HINCKLEY NATIONAL RAIL FREIGHT INTERCHANGE

Applicant's response to Deadline 6 Submissions [part 3 - LCC]

Document reference: 18.20

Hinckley National Rail Freight Interchange
 Leicestershire County Council Design Review Comments as presented to the Applicant
 team on 14.02.2024 and as discussed at a meeting with the Applicant team on
 15.02.2024

Written Statement of Oral Case ISH6 [Appendix C – Plan for A47 link road footway/cycleway design]

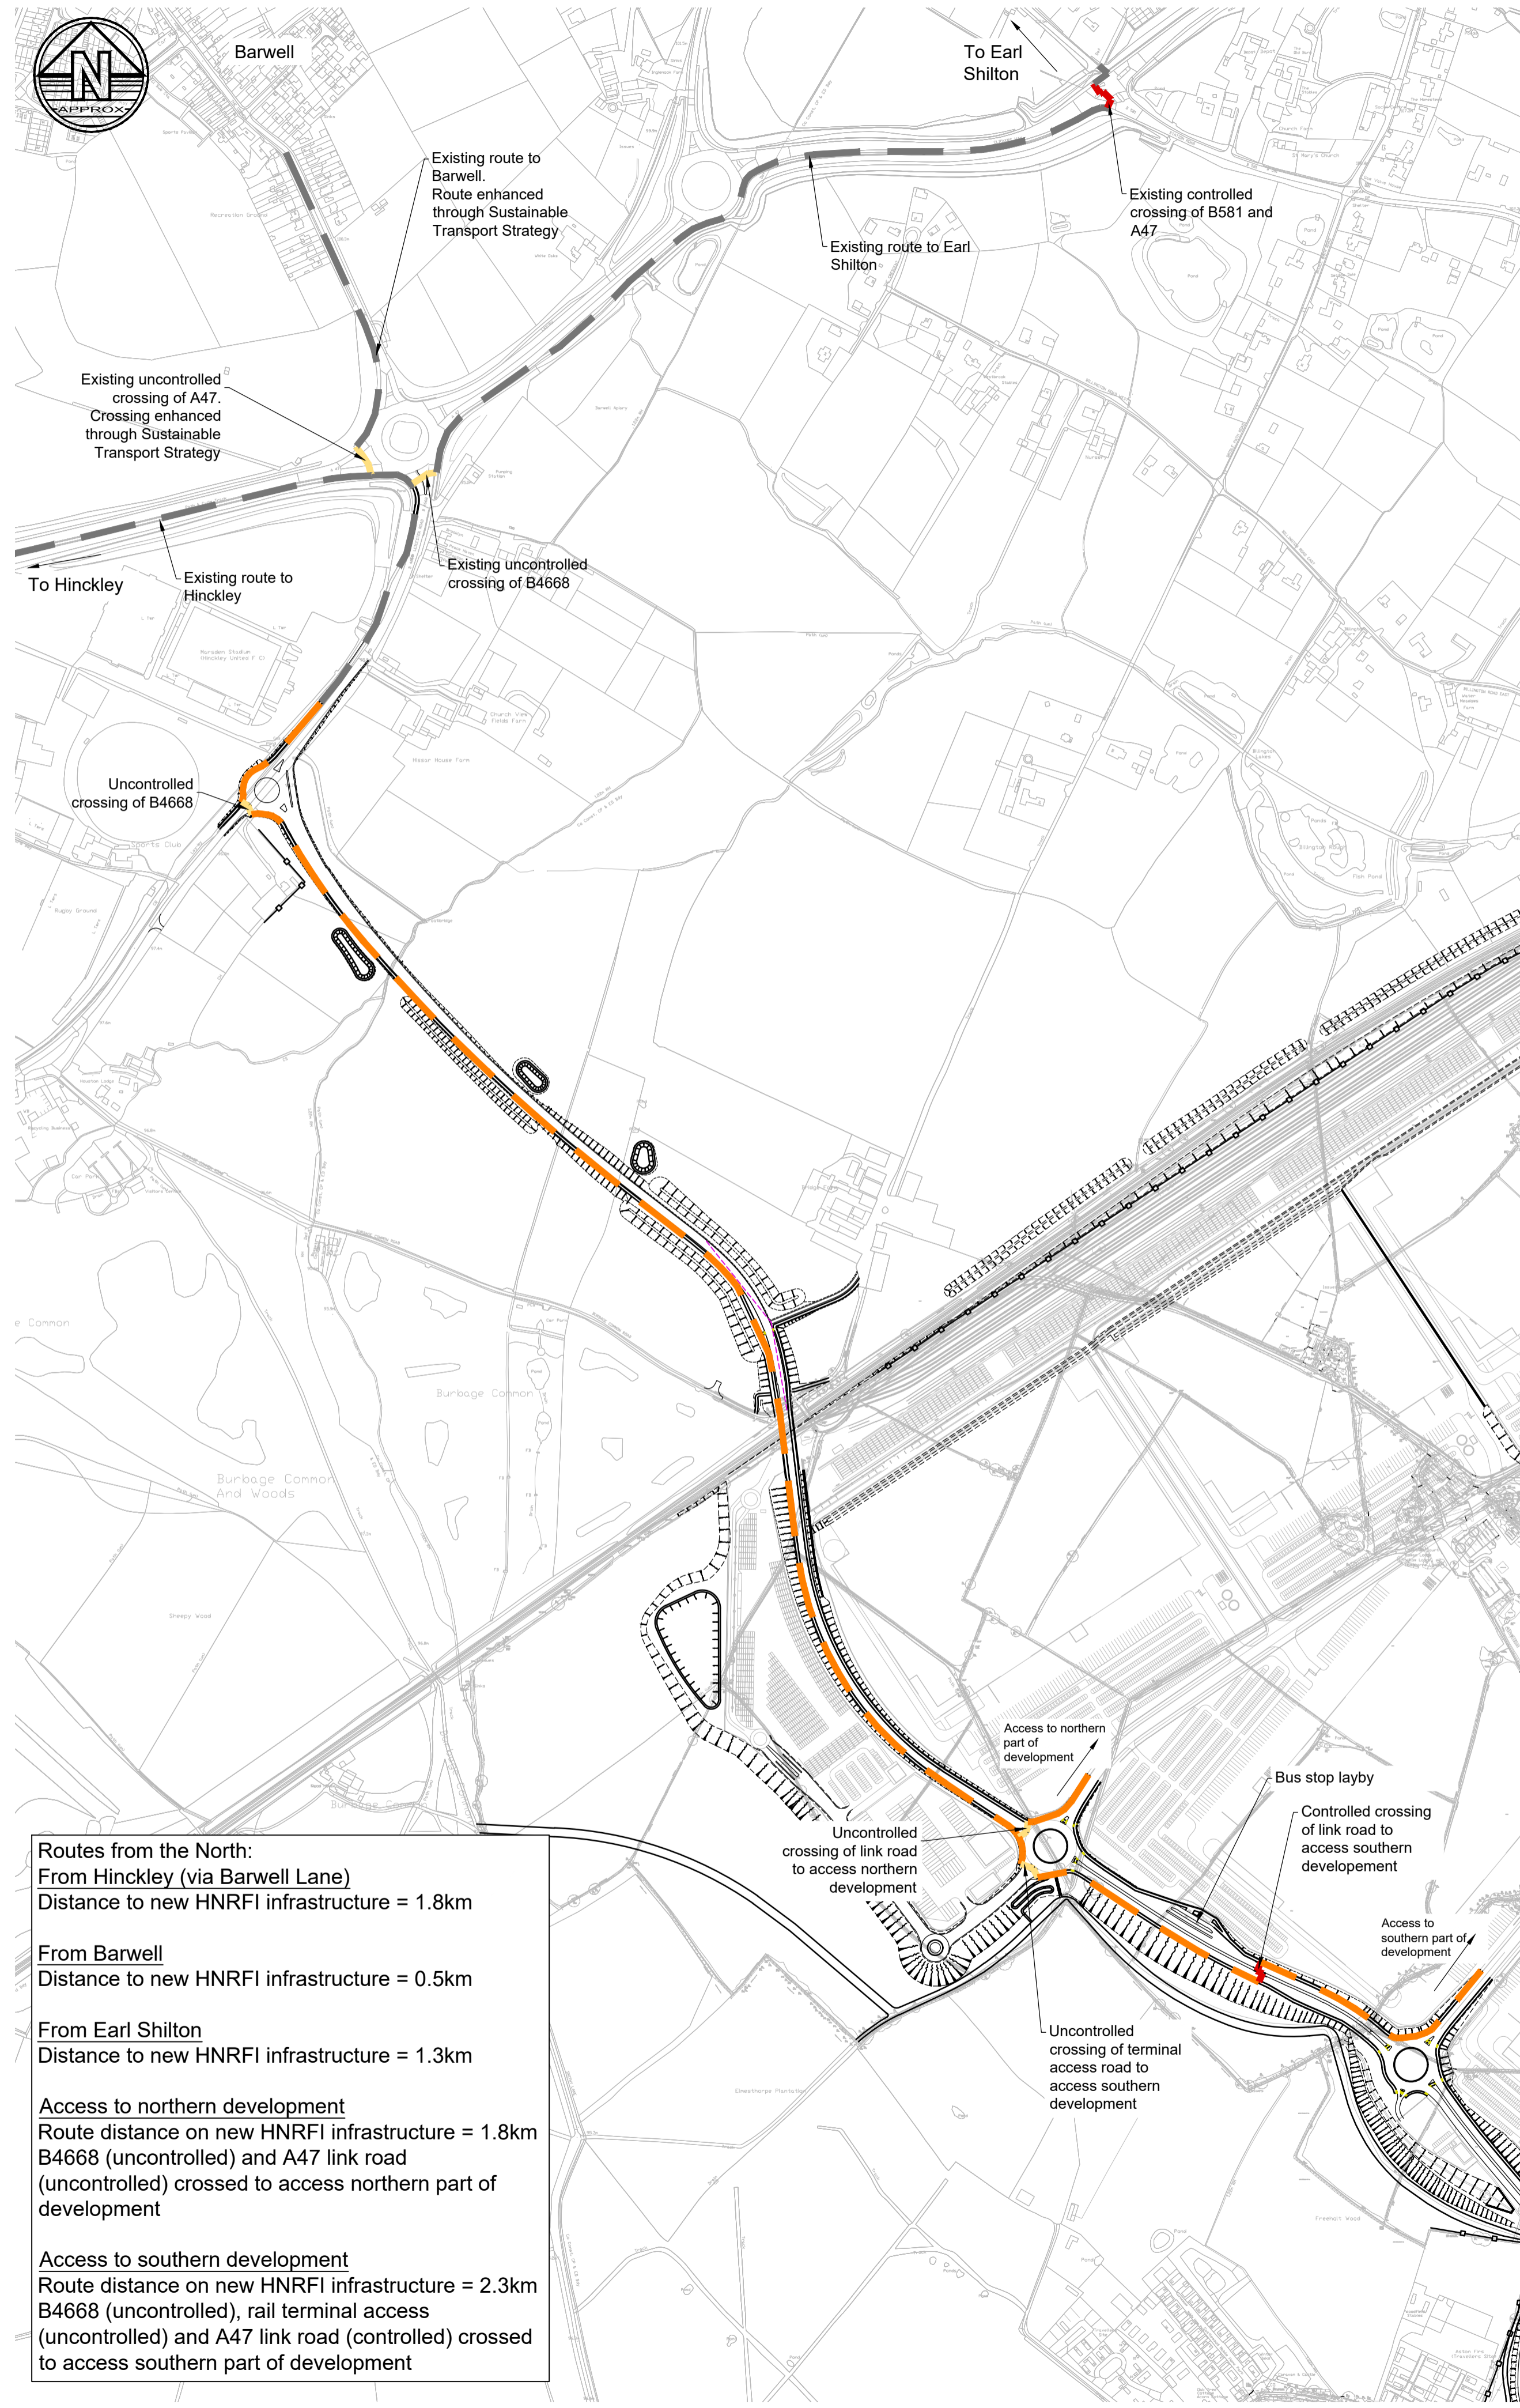
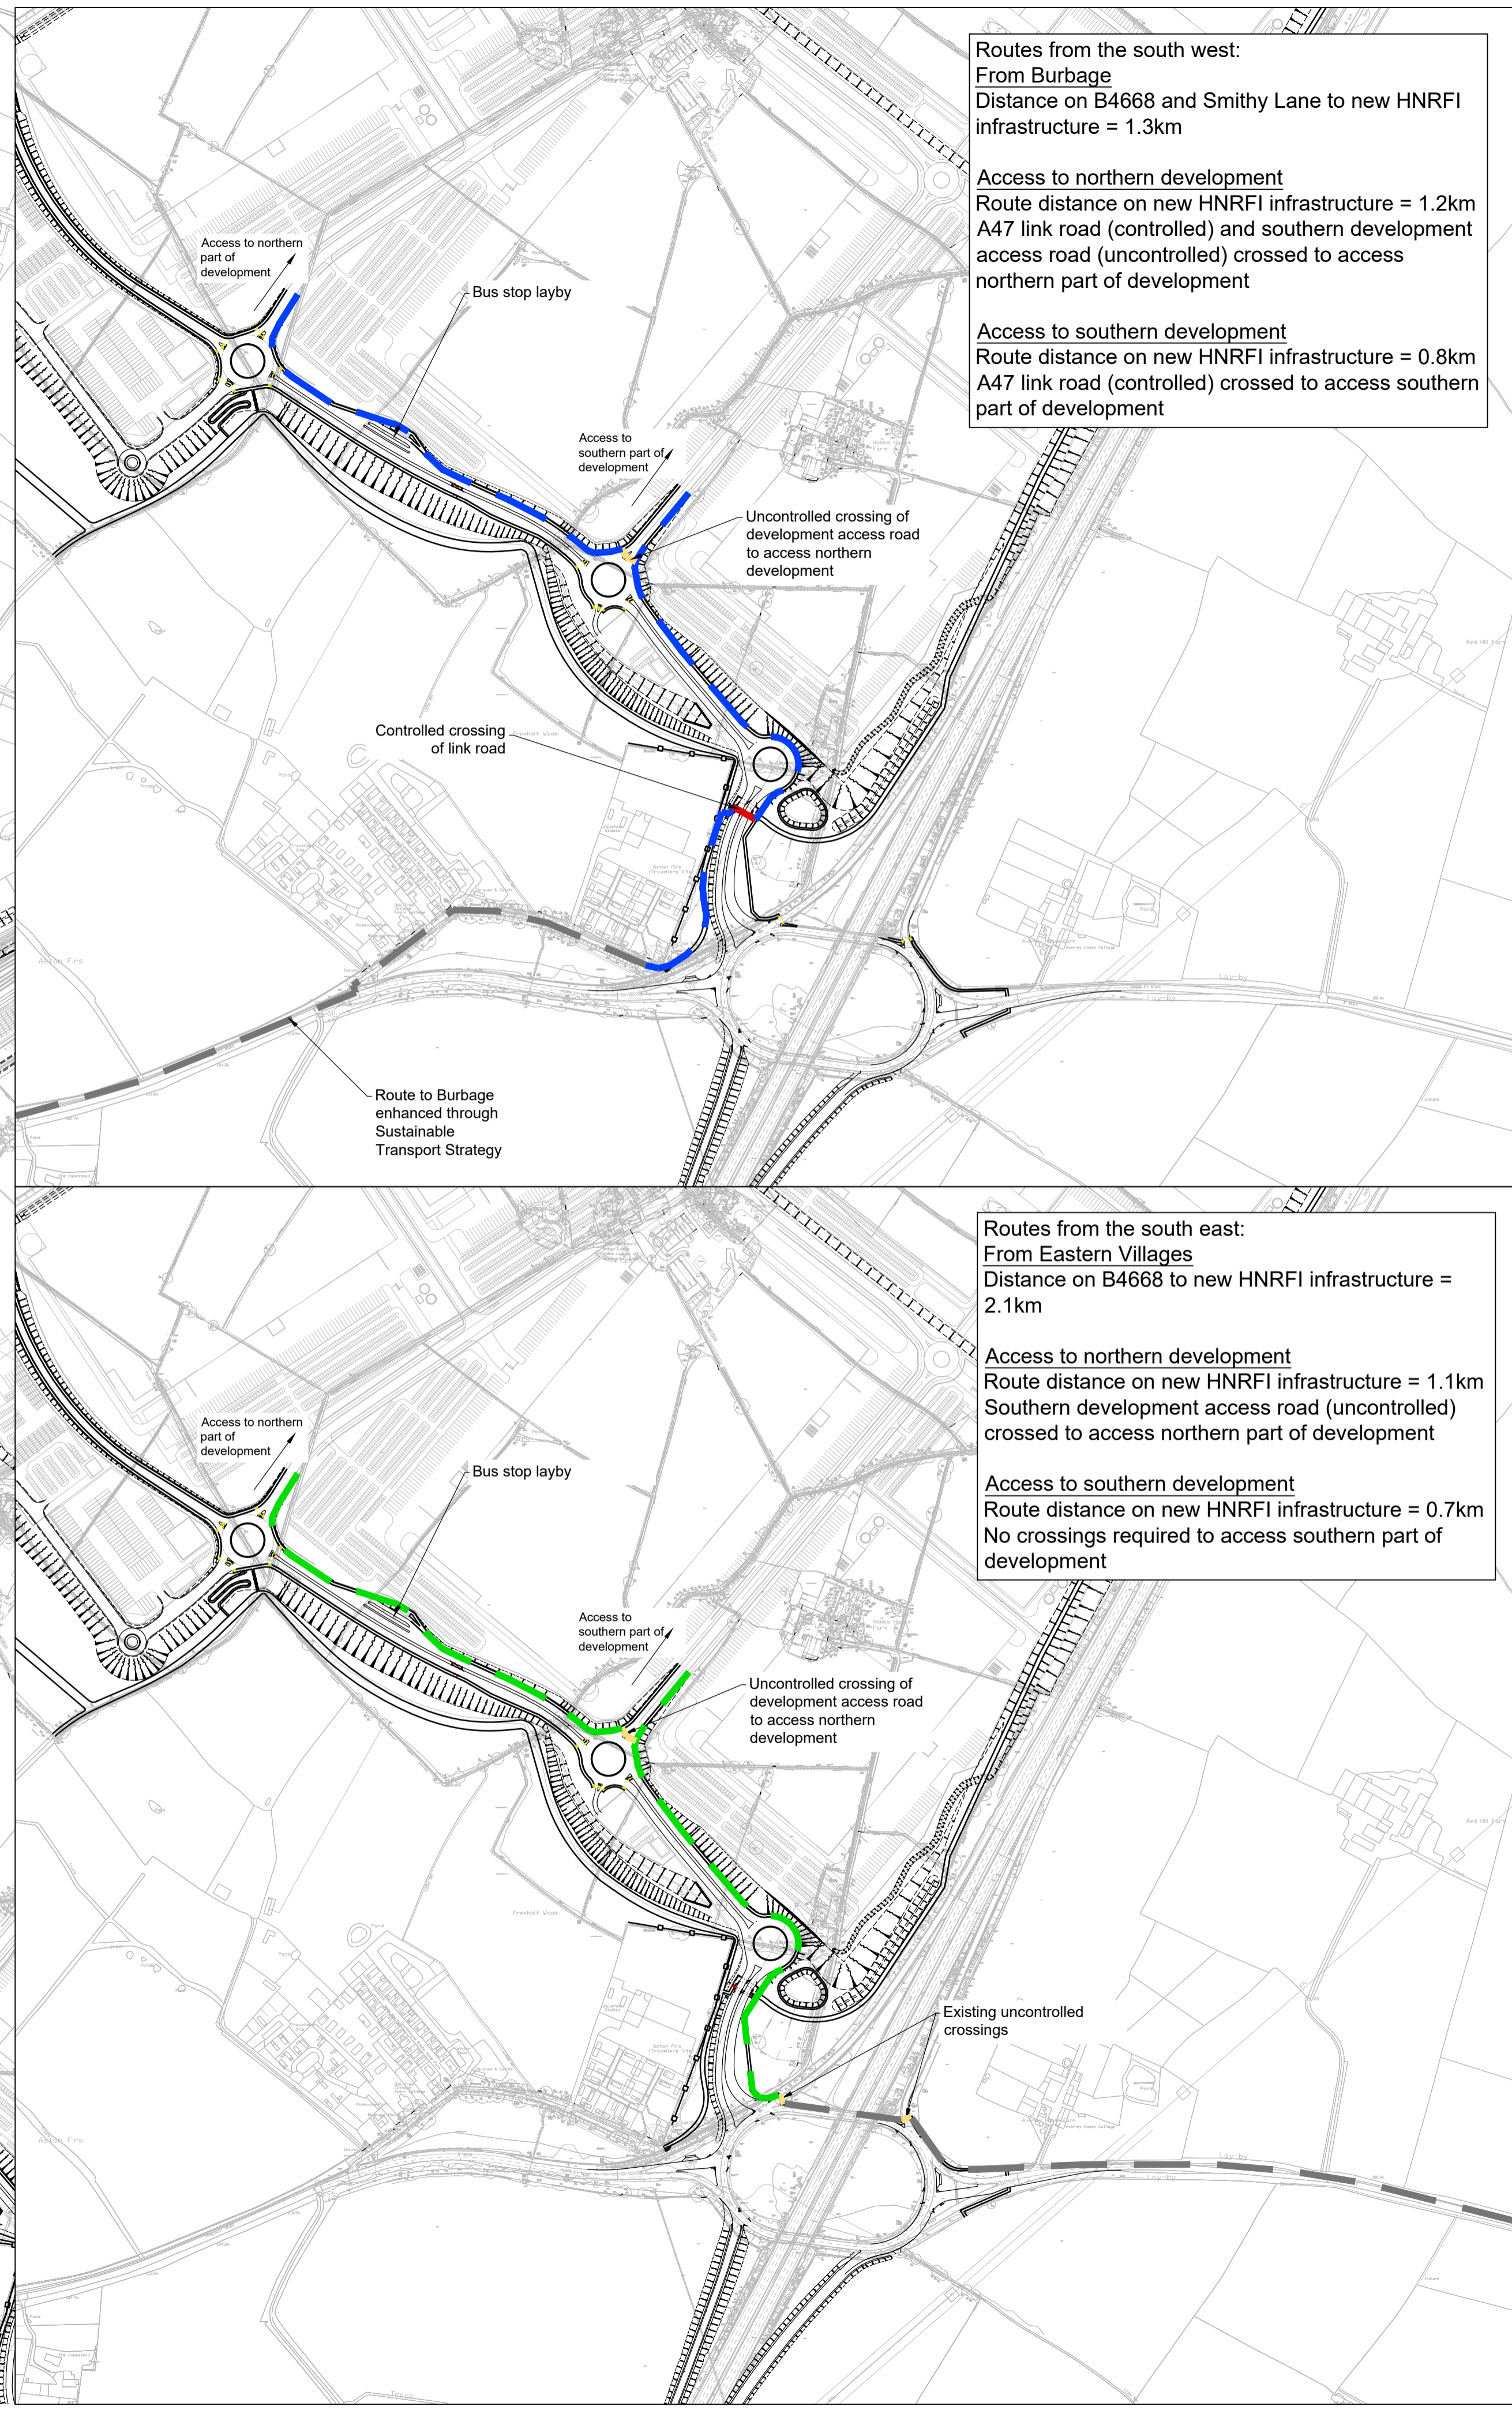
iii)	Poor connectivity for active travel users	The Applicant disagrees. This point has been addressed in the Applicant's previous responses at D5 and D6. See the Sustainable Transport Strategy (document reference: 6.2.8.1E) for an illustration of active travel routes to and from the development via the link road.
iv)	It is noted that for two junctions, B581 Broughton Road/Coventry Road and A47 Normandy Road/Ashby Road there is a S278 scheme which has been subject to ongoing technical review. The designs submitted do not reflect the s278 submissions and indeed reduce capacity.	LCC has been aware of the Applicant's position on the B581 Broughton Road/Coventry Road junction since before the Examination began. This scheme has been modelled using the PRTM flows and the agreed planning uncertainty log inputs to 2036. The submitted junction mitigates the impact of the HNRFI development and does not compromise its functionality in the future scenarios. The core difference between the plans is a short flare on the eastern arm Broughton Road included on the other developer's S278 - this does not compromise capacity according to the modelled outputs. Requirement 5(2) of the dDCO (document reference: 3.1D) clearly sets out that should the S278 not be delivered, then the proposed scheme will be delivered in its place by the Applicant. This was discussed and explained by the Applicant in ISH2.
